# Rezoning Transportation Analysis

Petition Number: 2020-030

General Location Identifier: Tax ID 06706105

Date	Description
03-23-20	First Review
4/22/20	Second Review

SCHEMATIC
SITE PLAN

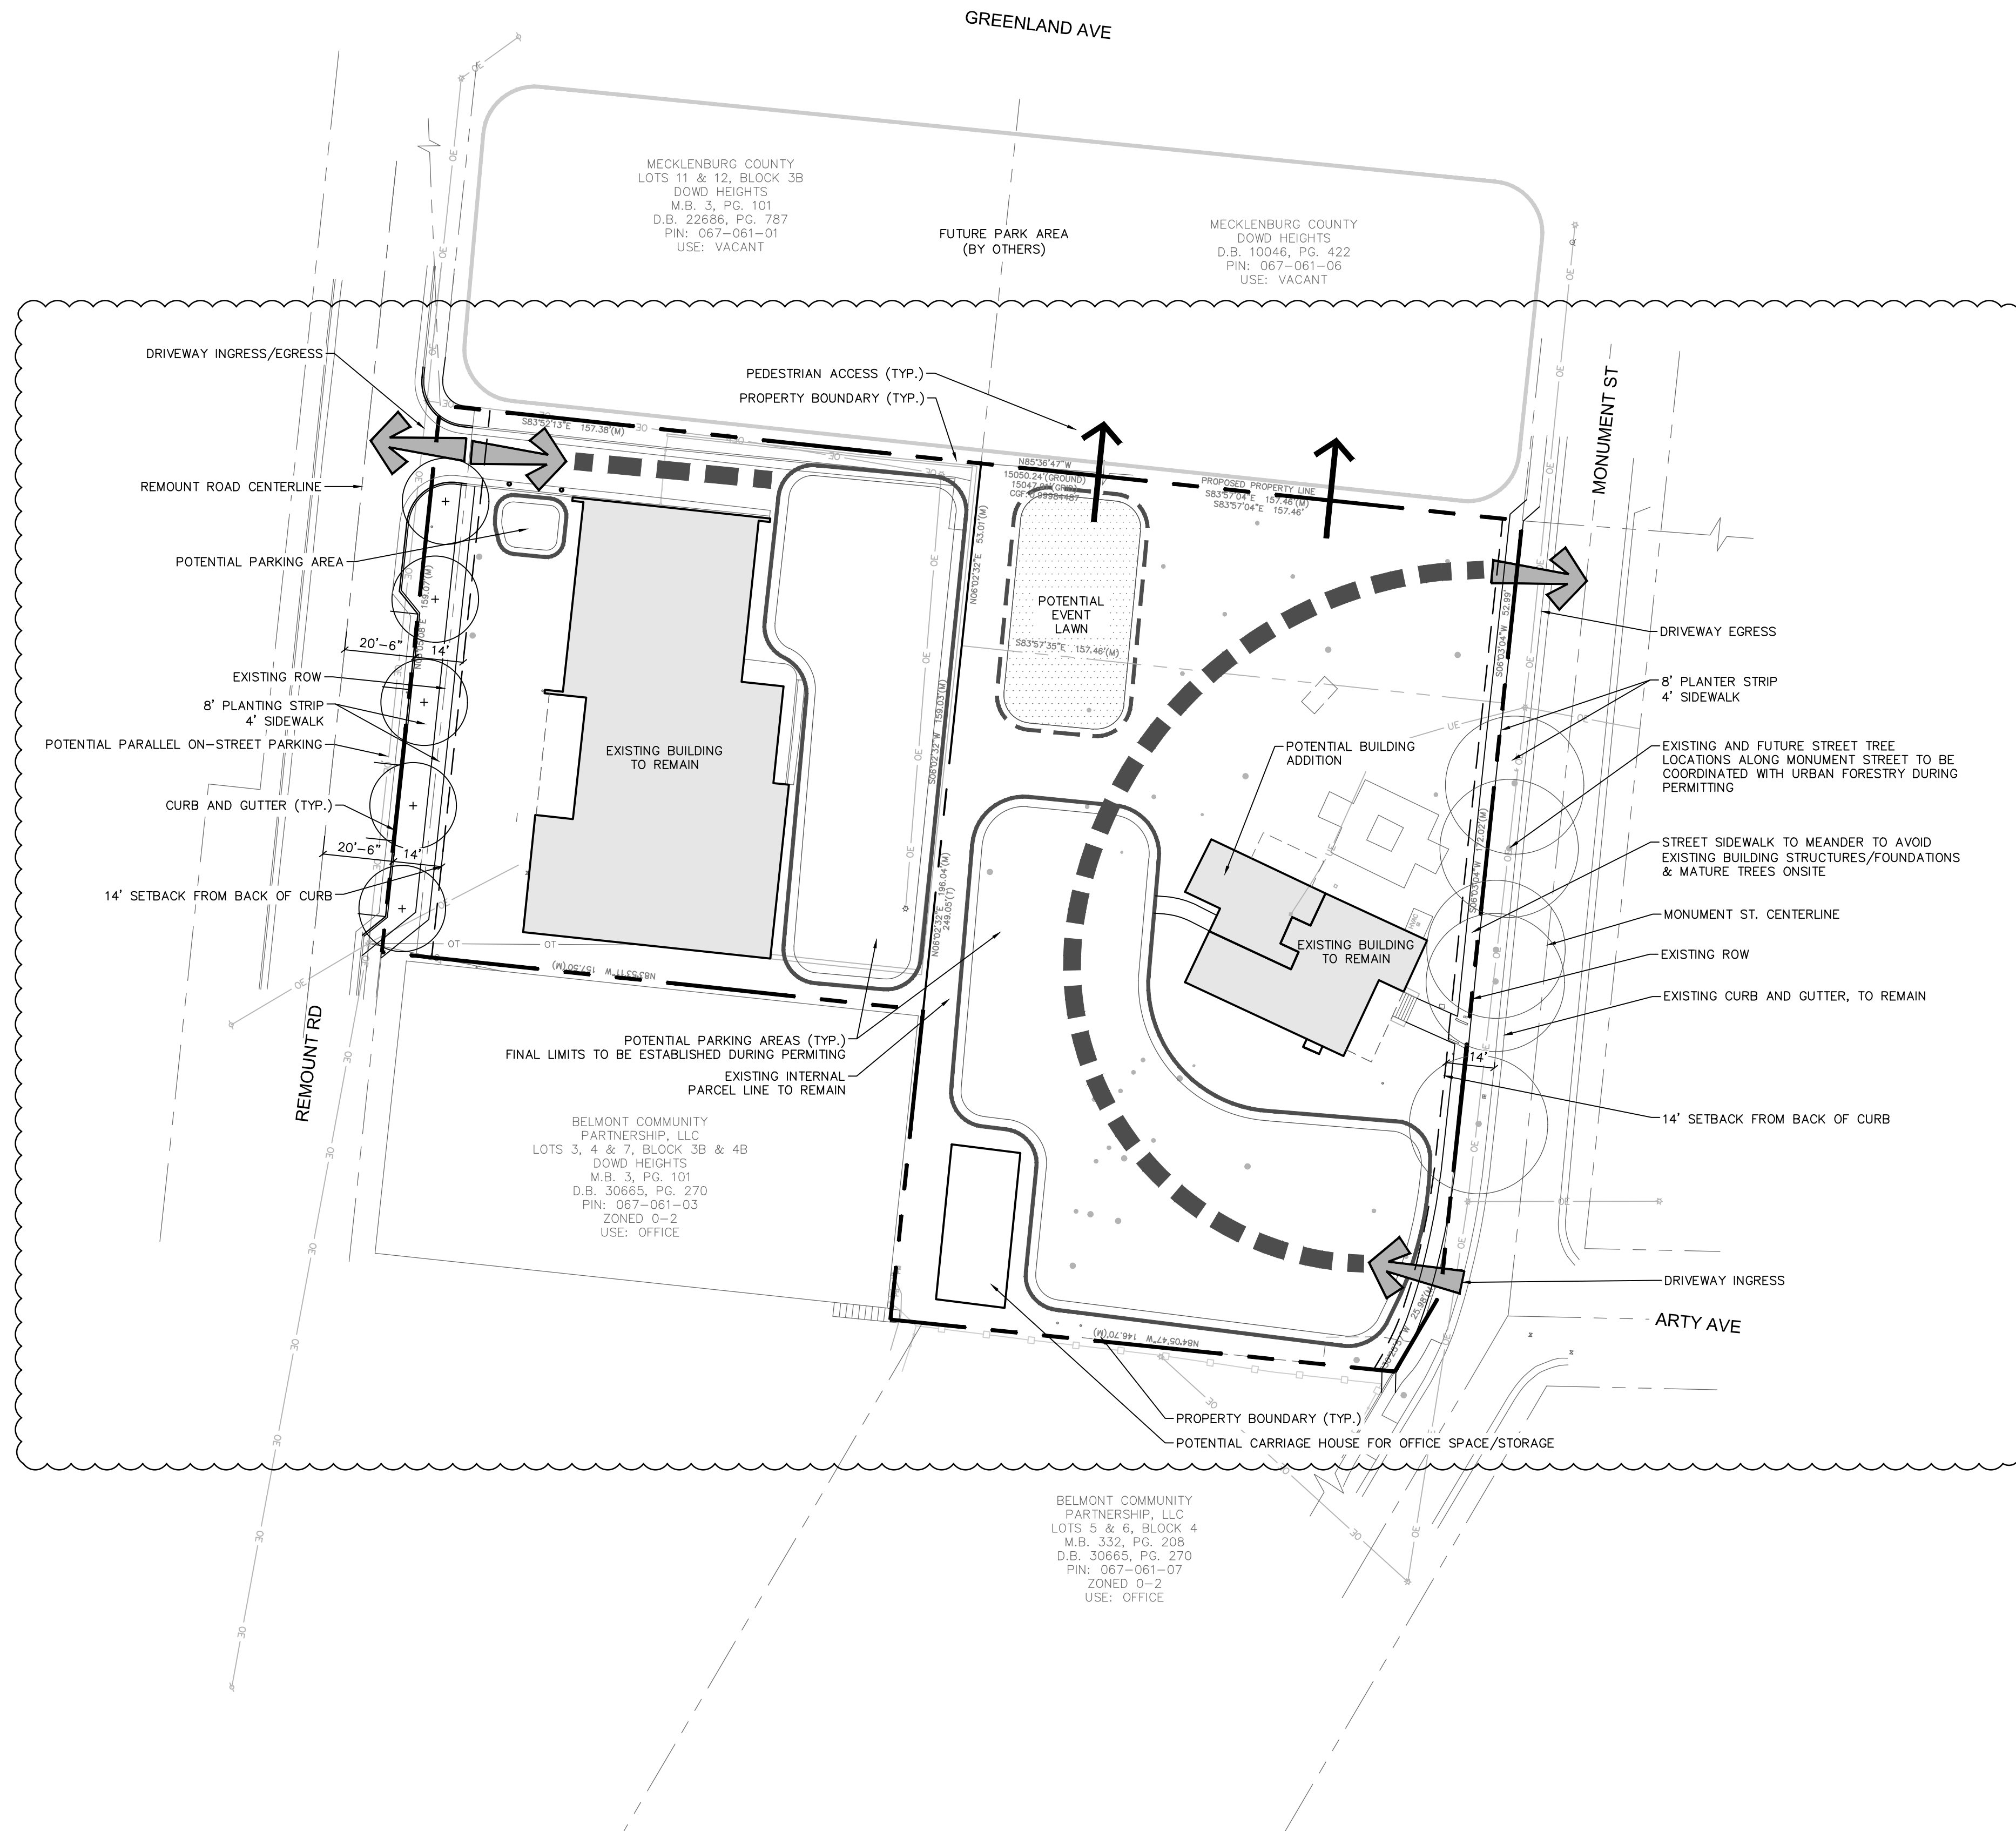
3. The petitioner should revise the site plan and conditional note(s) to commit to dedicate a minimum of 30 feet of right-of-way from the Remount Road centerline, per Chapter 12 of the Zoning Ordinance requirements for a Charlotte Regional Transportation Planning Organization (CRTPO) classified minor thoroughfare. The site plan should label and dimension the right-of-way from the road centerline.

4. The petitioner should revise the site plan and conditional note(s) to commit to construct an 8-foot planting strip, and 6-foot sidewalk on Remount Road and Monument Street, per MUDD requirements as required within Chapter 9 of the Zoning Ordinance. The proposed sidewalk should meander behind the existing trees where feasible, located within a sidewalk utility easement if outside of the public right of way. If sidewalk may not be relocated behind the trees, sidewalk may be proposed to meander inside of the existing trees with a minimum of 7-foot back of curb sidewalk. The site plan should label and dimension both items from the back of curb and gutter and road centerline.
